Lead Local Flood Authority
Post Point CHN 215
Hertfordshire County Council
County Hall, Pegs Lane
HERTFORD SG13 8DN

Date 14 November 2022

**RE 6/2022/01853/MAJ - Eisai Europe Limited, European Knowledge Centre,
Mosquito Way, Hatfield, AL10 9SN**

Figure 3-2 Phasing Layout

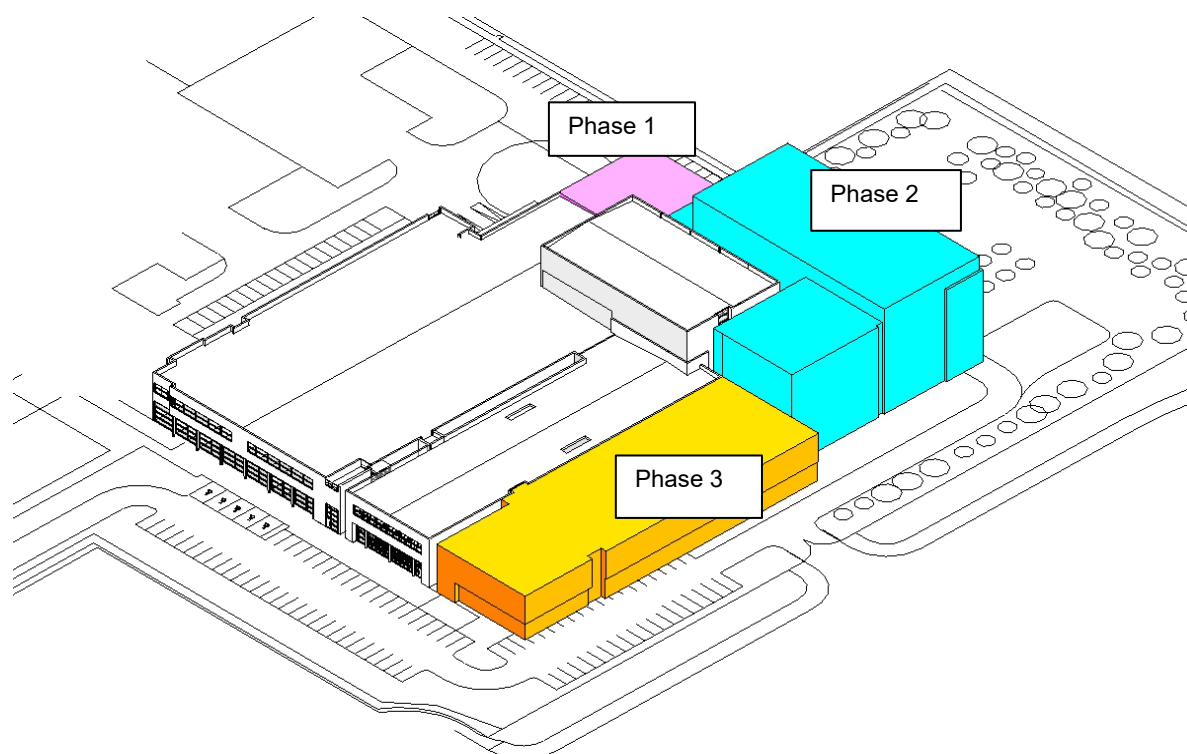
- It is still unclear how the proposed development is proposing to support amenity and biodiversity benefits.
- In the section 4.4.1 Option 1 of the DS Part 1 it is understood that the storage volume required from the geocellular storage may be in error and confirmation is required.
- Based on the proposed phasing plan (DS figure 2-3) it is unclear whether all relevant areas are included in the DS proposals in the Appendix D.
